**Re: PA22-024- Marysville 44th PRD – Technical Review 1
7315 / 7417 44th St NE – APN(s) 30053500303700 / 30053500303600**

This letter is provided as response to comments dated August 17, 2022. Each item has been carefully reviewed and considered and the following is a summary of how each item was addressed.

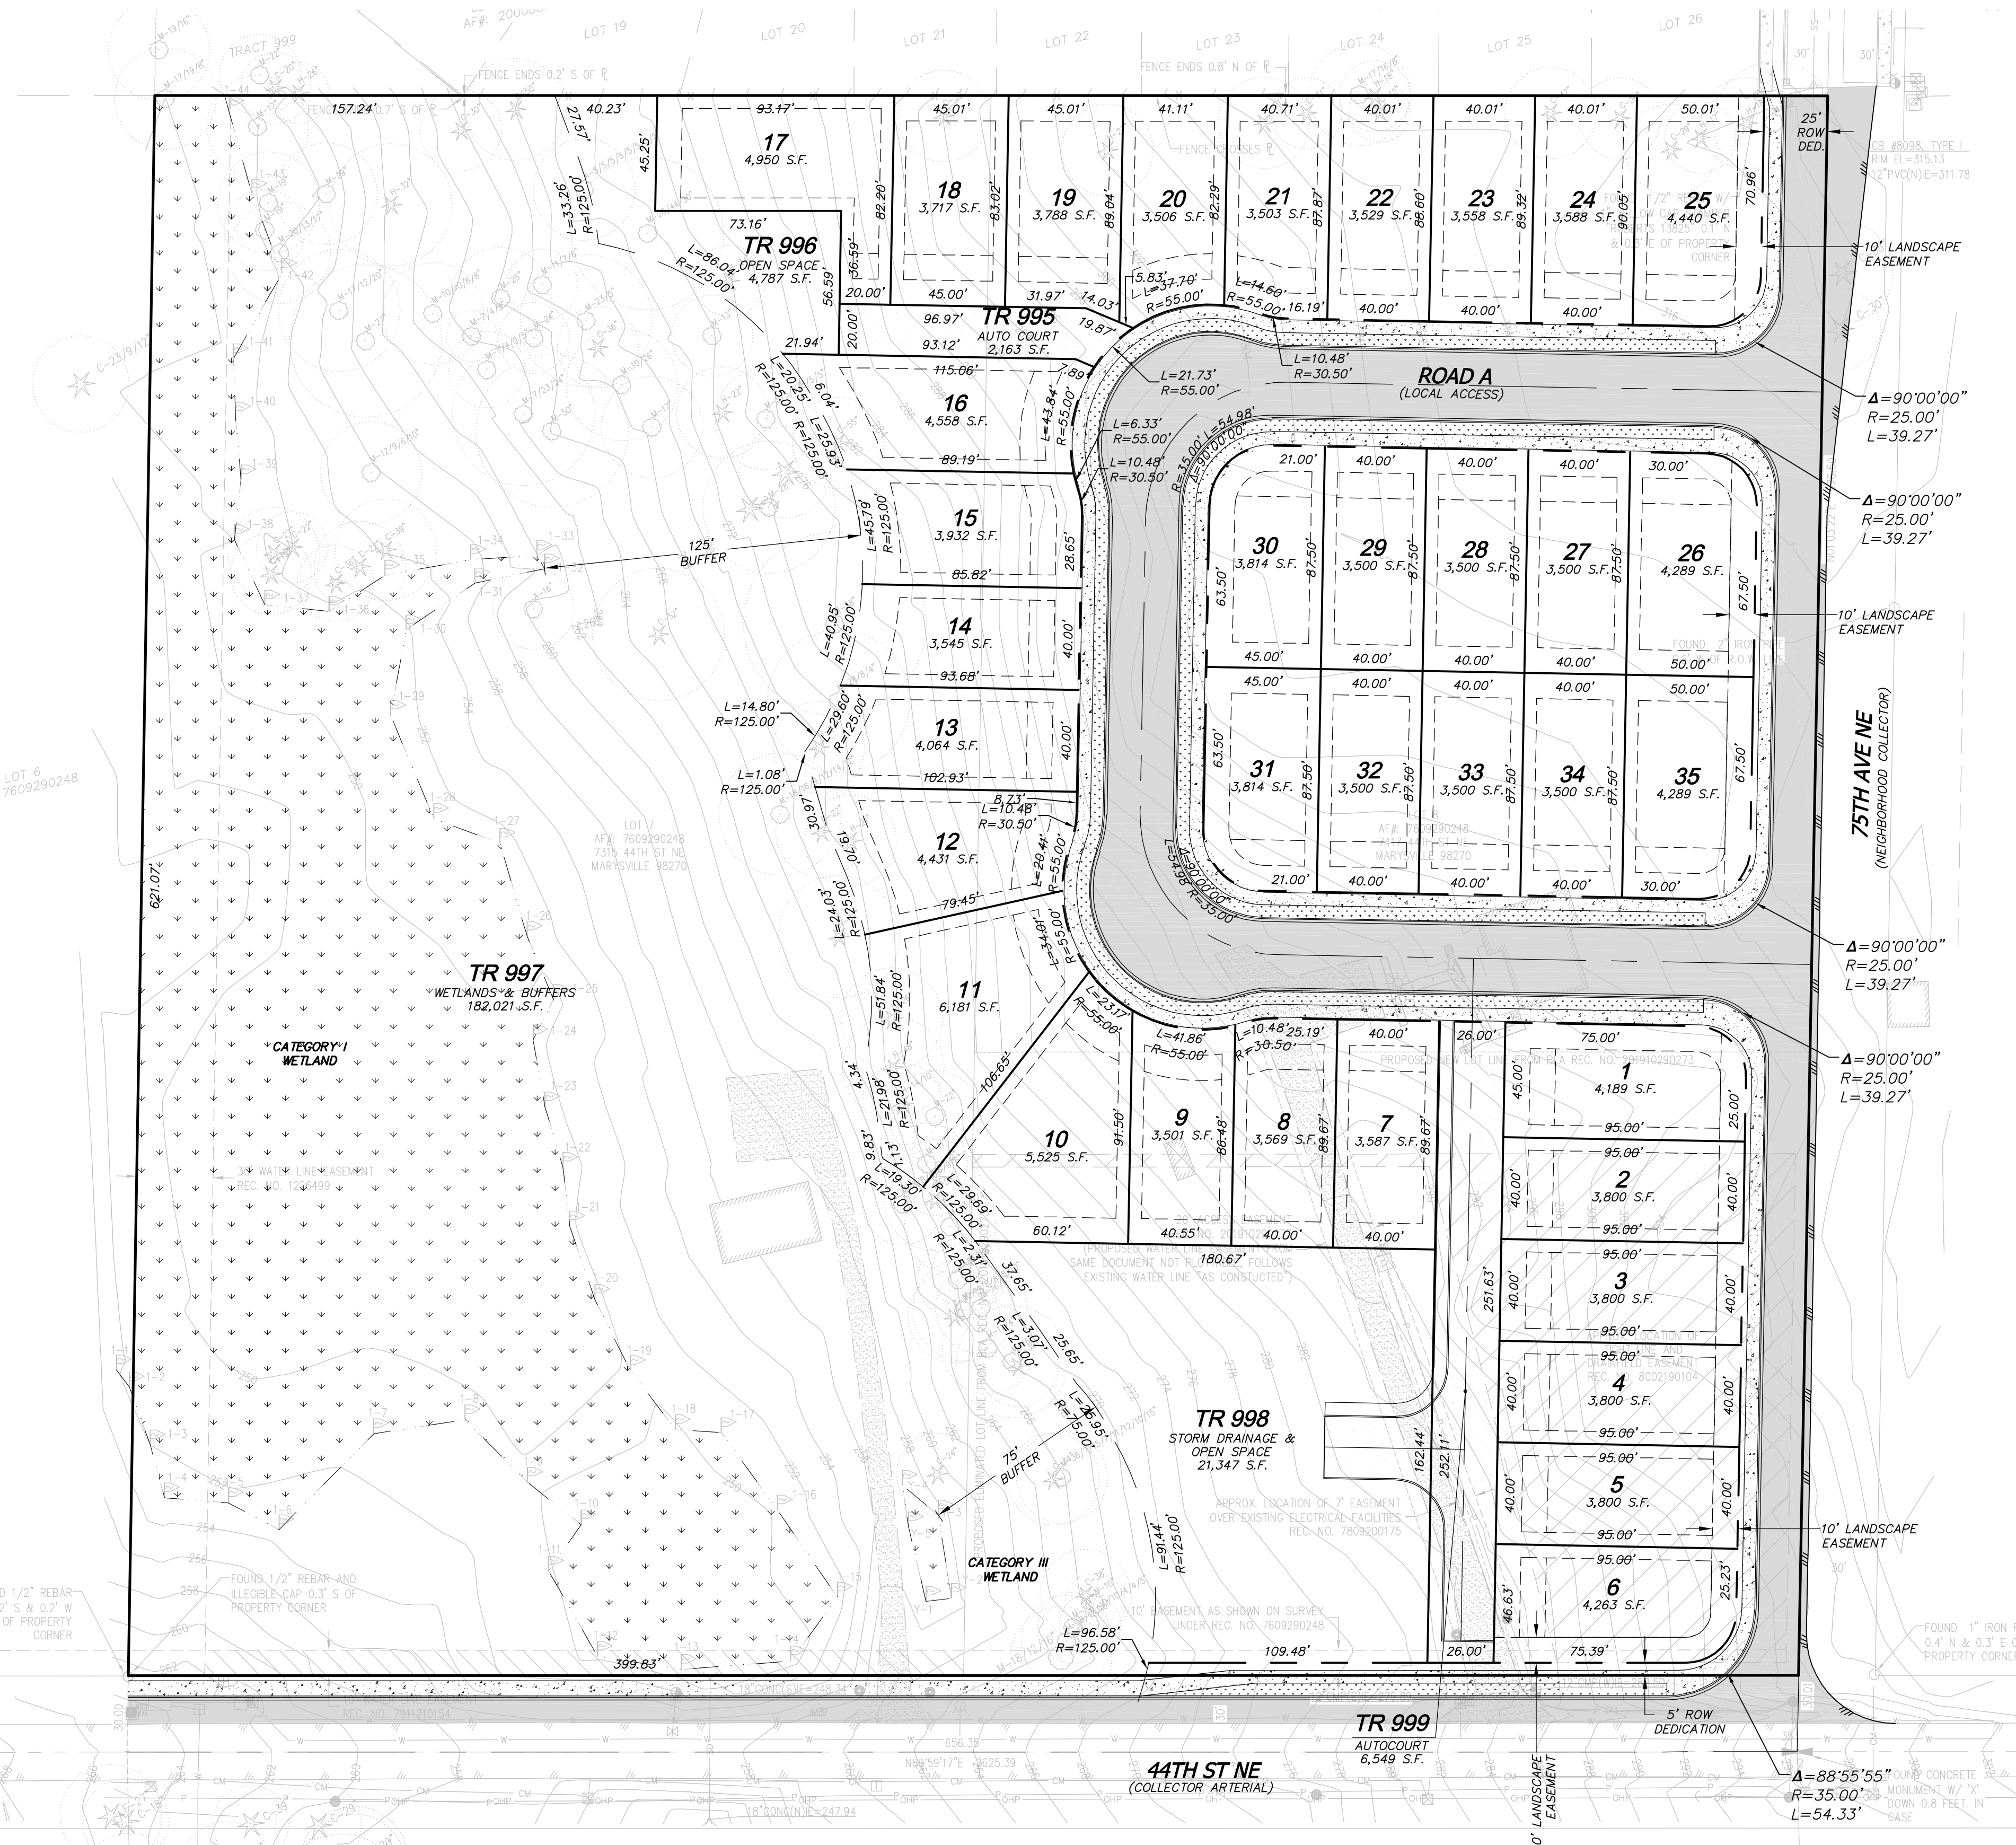
2. To aid in quick reference and review, provide a table within the site plan that includes details for Tracts 995 – 999, including tract size and proposed use.

3. Revise the proposed building envelope lines of Lot 17 to include a 10 ft. setback from the eastern property boundary, north of the panhandle.

See table on cover sheet.

Revised.

LANDSCAPE PLAN

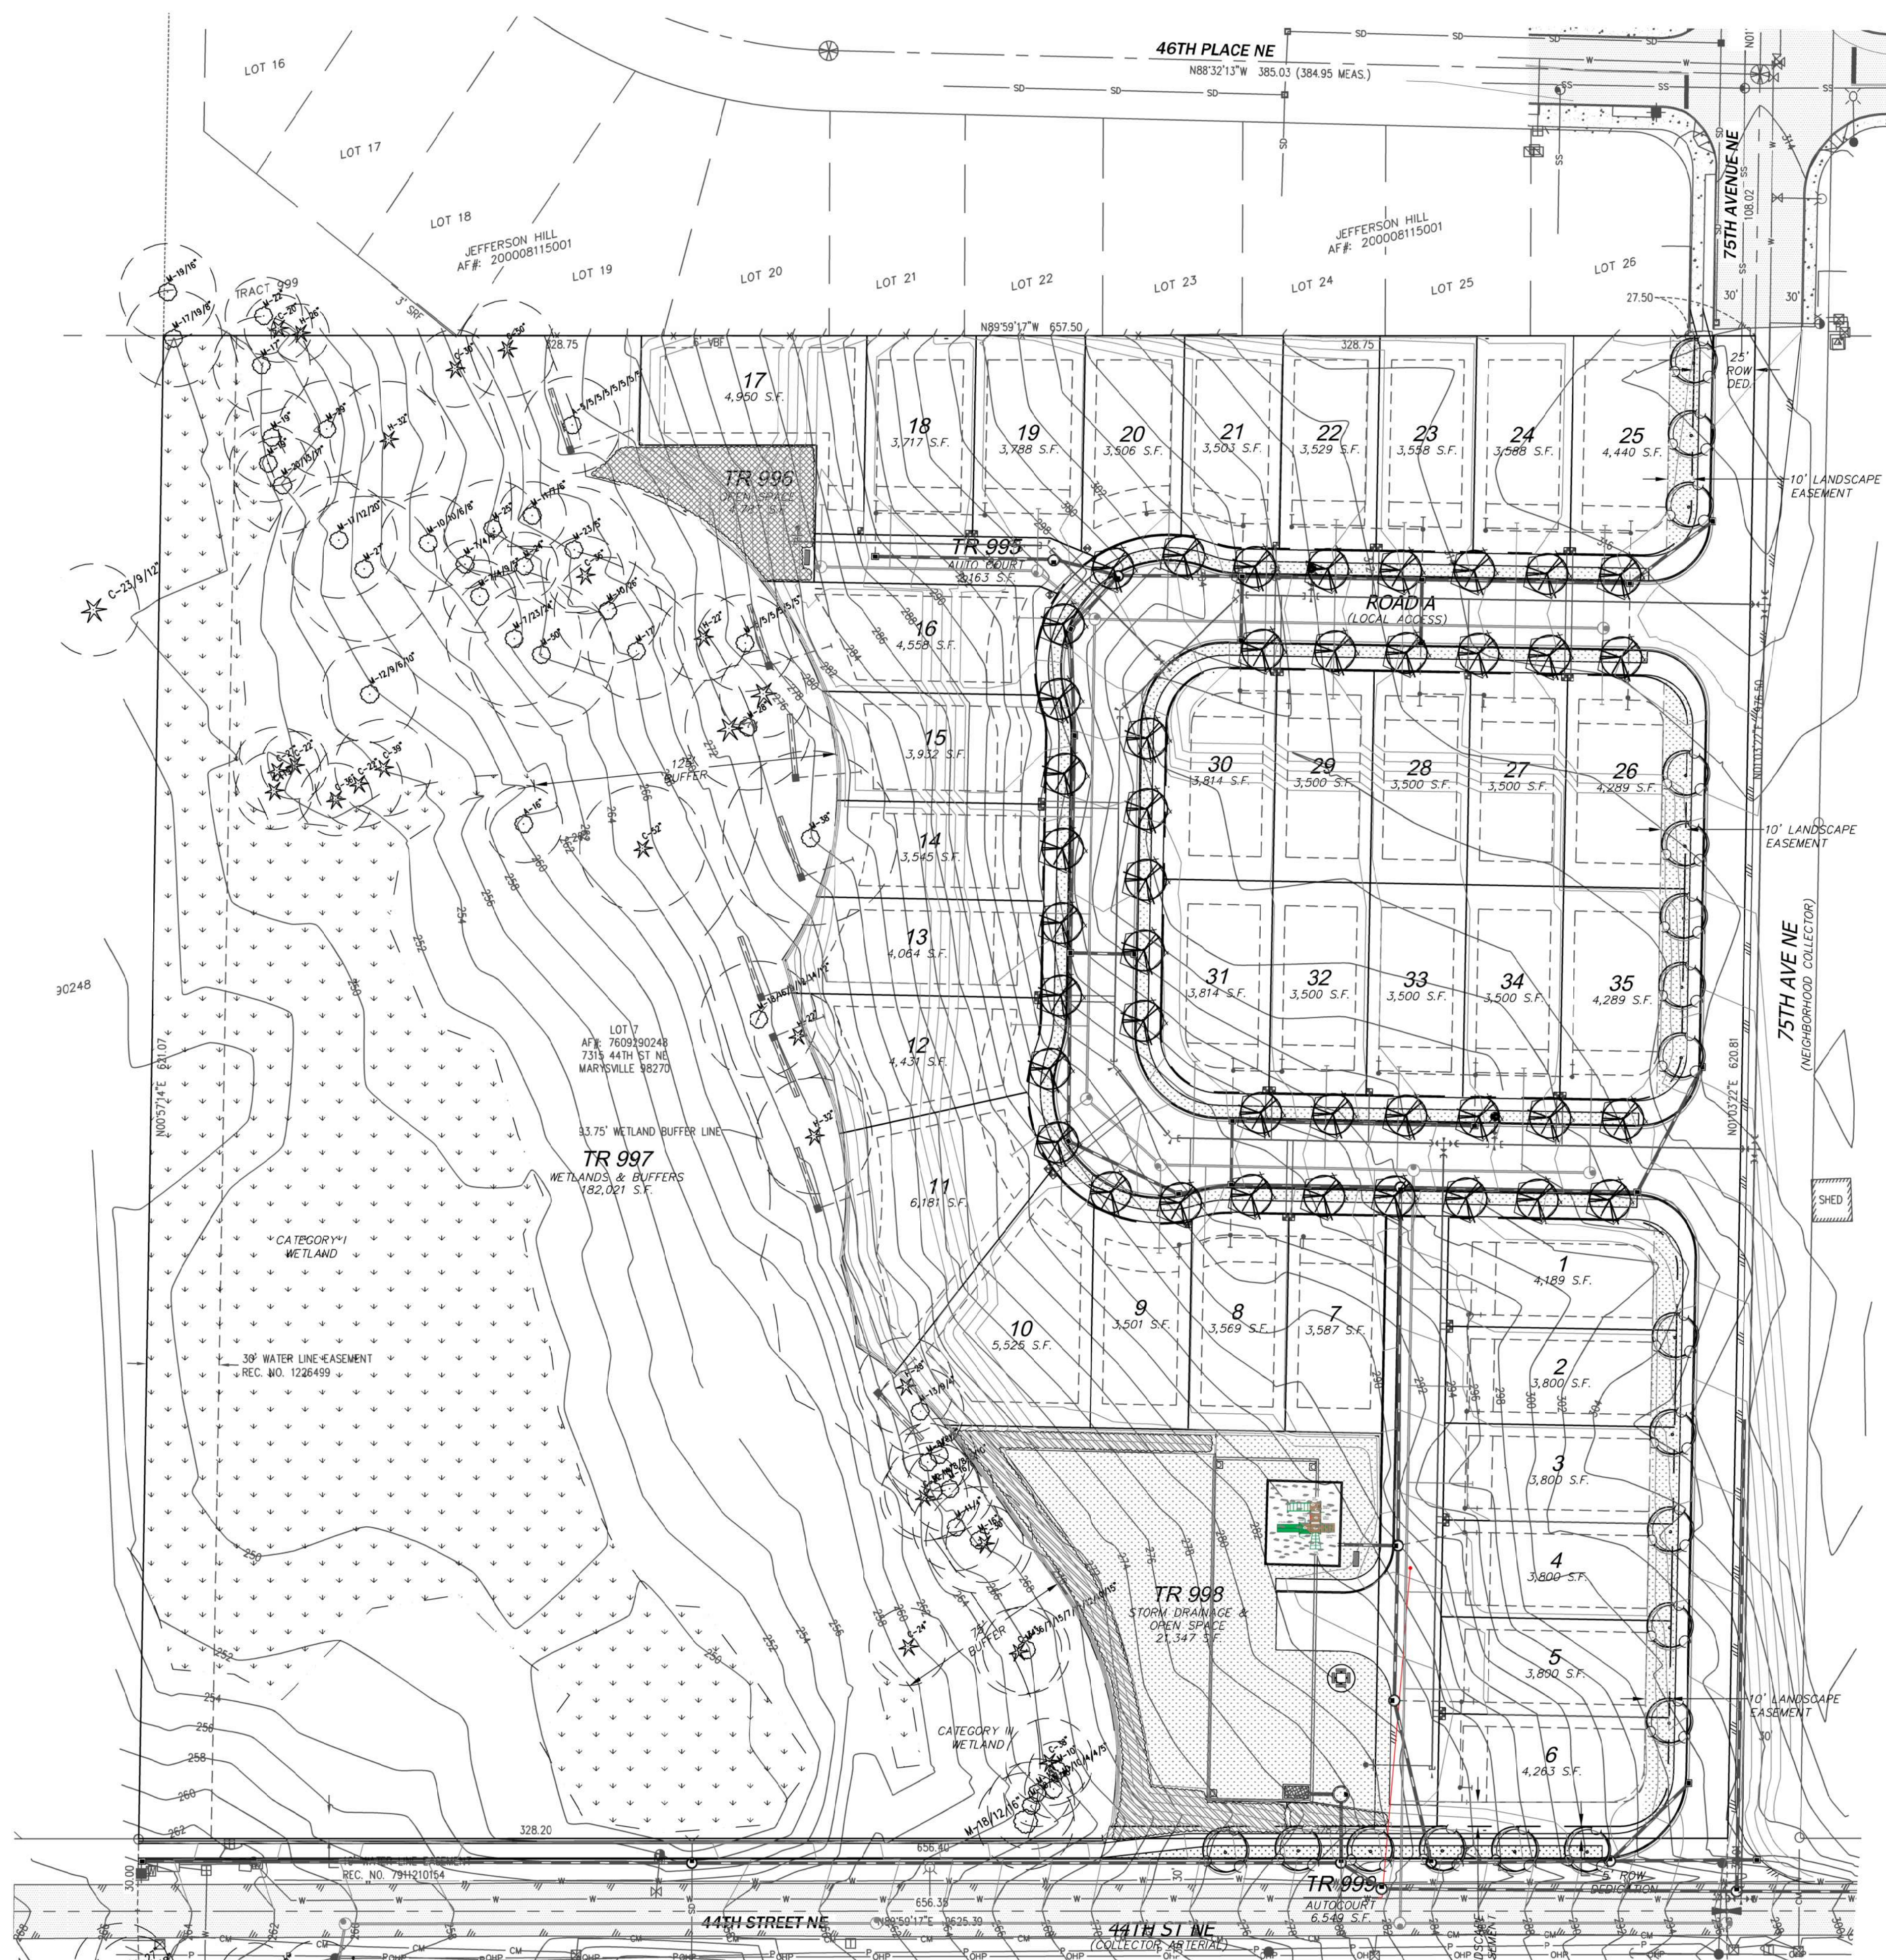
3. The vault access must extend to the vault outlet structure and water quality filter. Access must be suitable for a vector truck. Bring all precast vault lids to the surface and show them on the landscaping plan. This will ensure there are no conflicts between park amenities and the vault maintenance access.

Access has been extended. Final design will include auto turn analysis to accommodate a vector truck.
